Our Ref.: JPP.HPC.724

11th July 2023

Planning application: 21/00517/F
Land Used For Motocross Stratford Road A422 Wroxton OX15 6HX

Creation of a motocross track and soft landscaping scheme and the change of use of agricultural land to hold moto-cross events including set-up, take down and private practice sessions, with associated camping site, for up to 65 days per year and agricultural grazing (retrospective)

Figure 4 Location Plan, showing the site in relation to bounding features

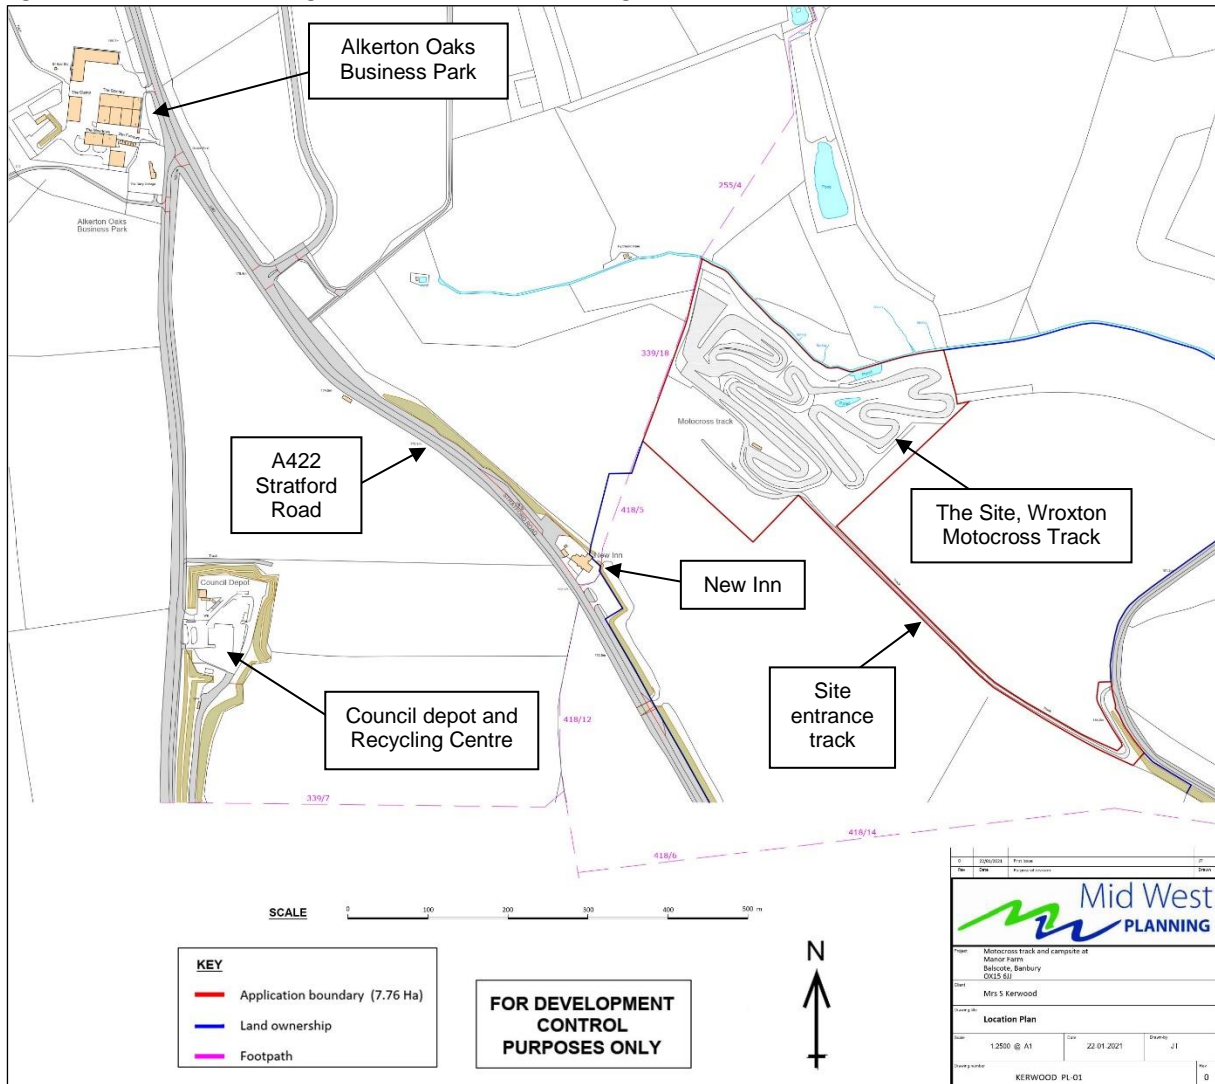
4. The red line site area should include the means of access to the public highway^{1 2} and any required visibility splays. Therefore, in this case the red line as drawn is incorrect. It should extend to include proposed vision splays, which it does not. The red line location plan also omits a sizeable section where motorhomes and caravans have been regularly parked: an area to the southeast of the main body of the site. To take the current application through to determination could well put the Local Planning Authority at risk of legal challenge. The current application is invalid and should be returned to the applicants. Due to the errors with the submitted application the correct statutory consultations have also failed to take place.

6. On a related matter, the blue line depicting other land outside of the application site within the applicant's control was evidently incorrect at submission, as an area to the northeast of the application site has been added. IF that area is required for mitigation, it should properly be included within the red line area.
